From: Martyn White
Sent: 10 July 2019 10:44
To: Maria Tomalova <Maria.Tomalova@arun.gov.uk>
Subject: BR/120/19/PL & BR/121/19/L

BR/120/19/PL & BR/121/19/L

The bandstand is a Grade II Listed Building. It is located on the promenade over-looking the beach.

824/04

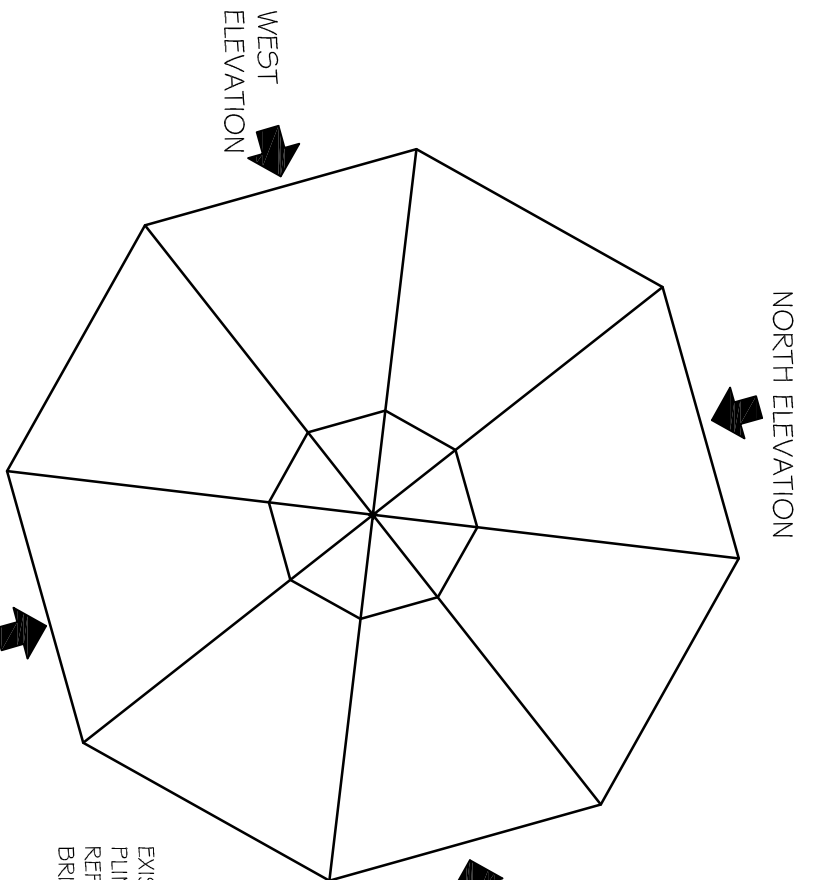
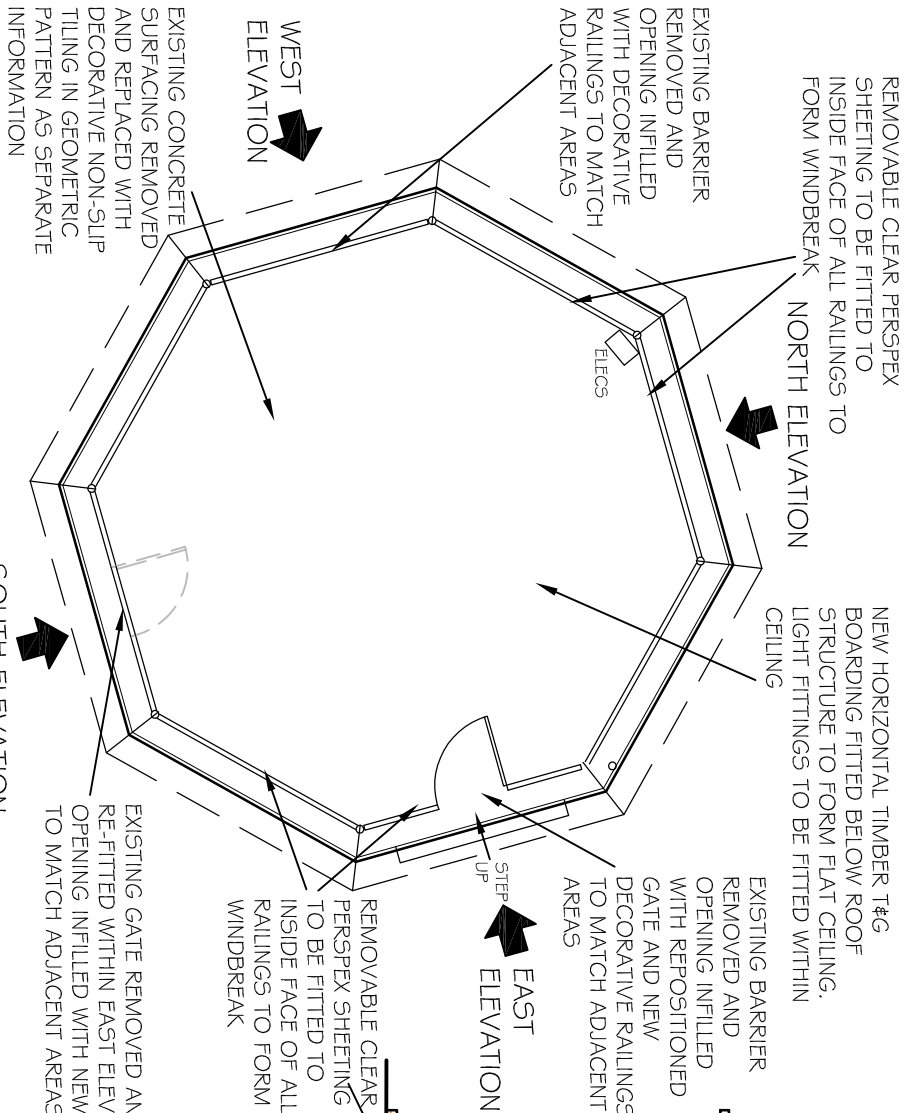
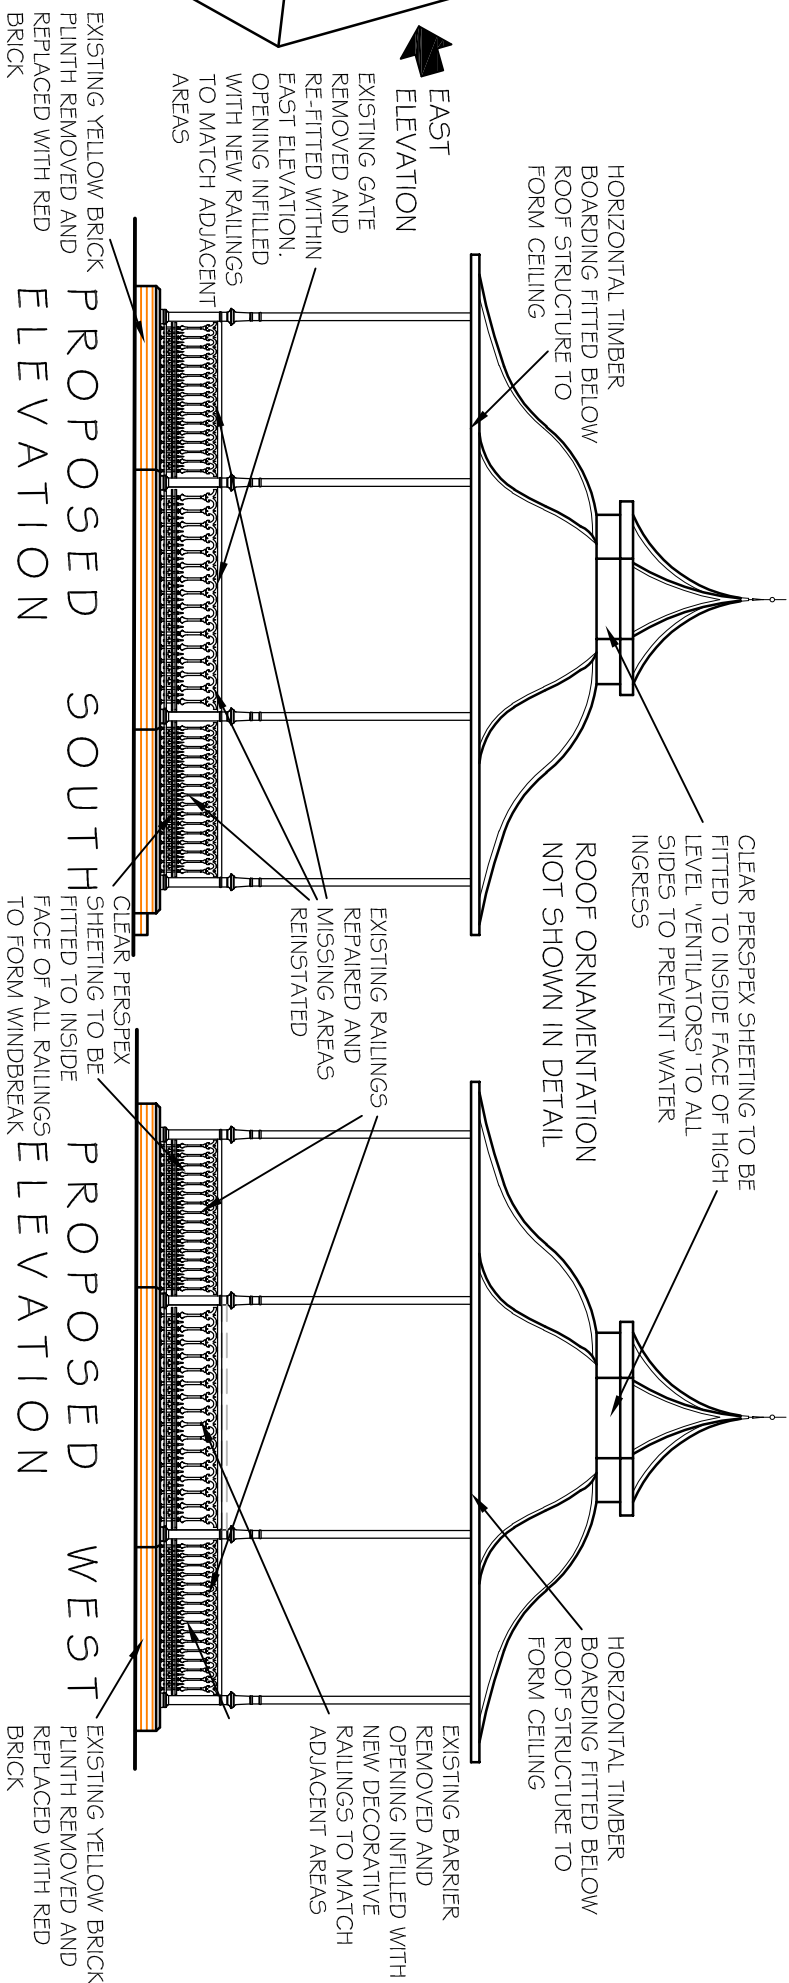
However, there are some issues which require clarification. It is not clear from reviewing the information why the location of the gate is to change.

Further, scant information has been provided regarding the proposed Perspex sheeting; how will it be fixed to the structure? Will it form a permanent element of the structure, or will it be used on a temporary basis (and removed when not required)? Further, what size will the panels be? What would the quality of the materials used be? At present, such an issue is considered to be problematic.

Based on the information currently provided as part of the application, details of the proposed red bricks to be used to replace those used for the brick plinth will need to be provided. Further, all of the colours to be used should be agreed with the LPA.

REV	DESCRIPTION	DATE
PROJECT BOGNOR REGIS BANDSTAND THE ESPLANADE BOGNOR REGIS WEST SUSSEX		
DRAWING TITLE REFLECTED CEILING PLAN AND LIGHTING PLAN

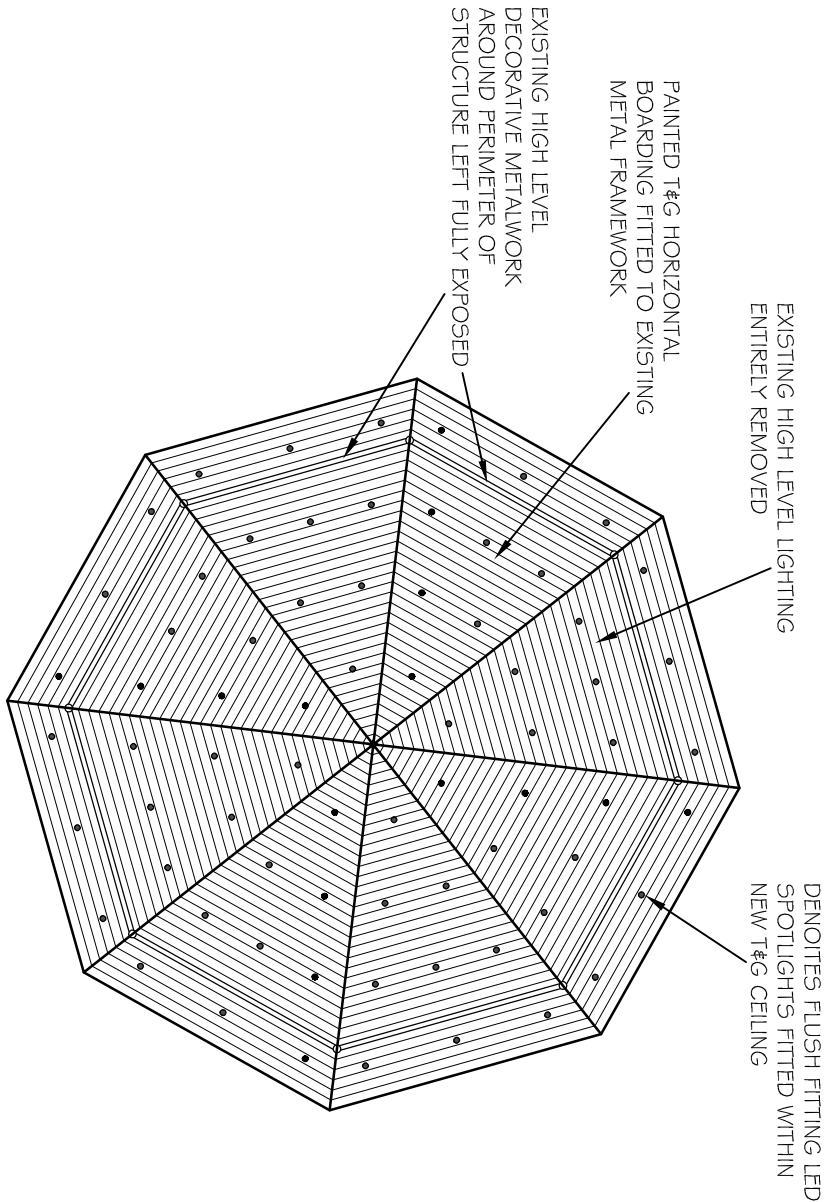
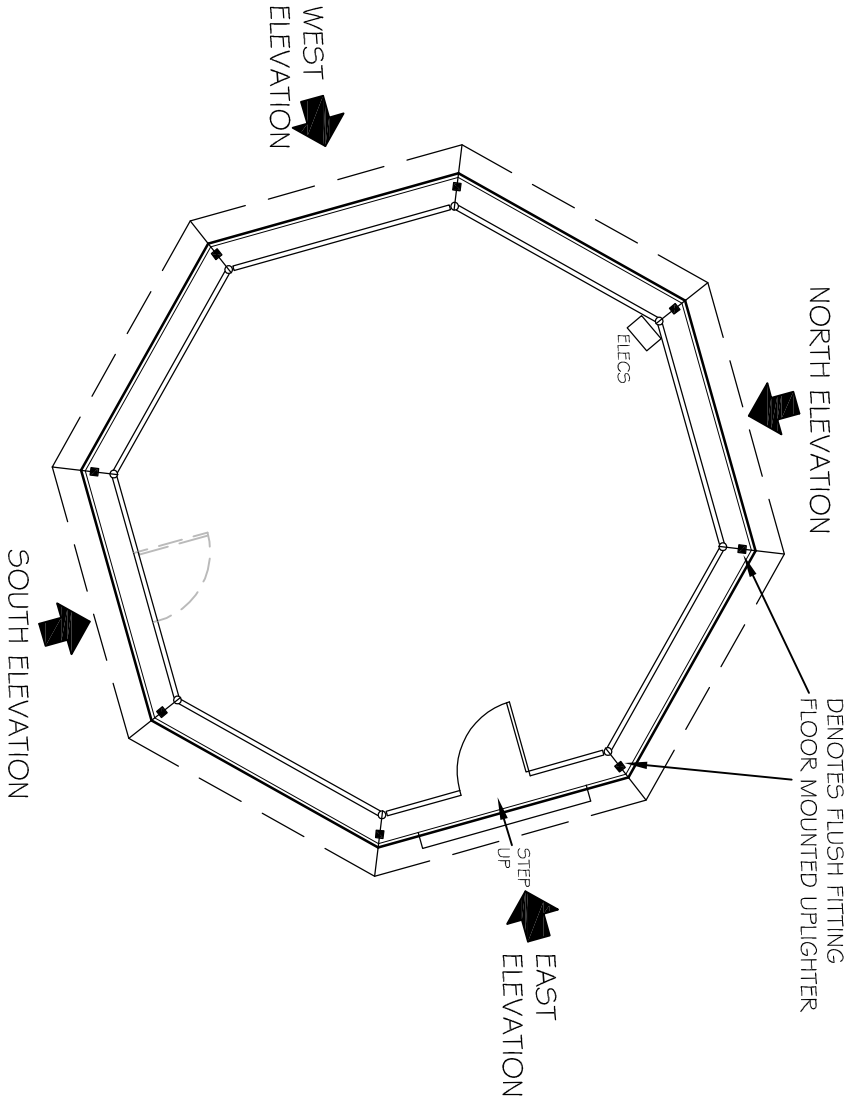
Also how will the horizontal timber boarding to be fitted below the roof structure to form a ceiling be treated?
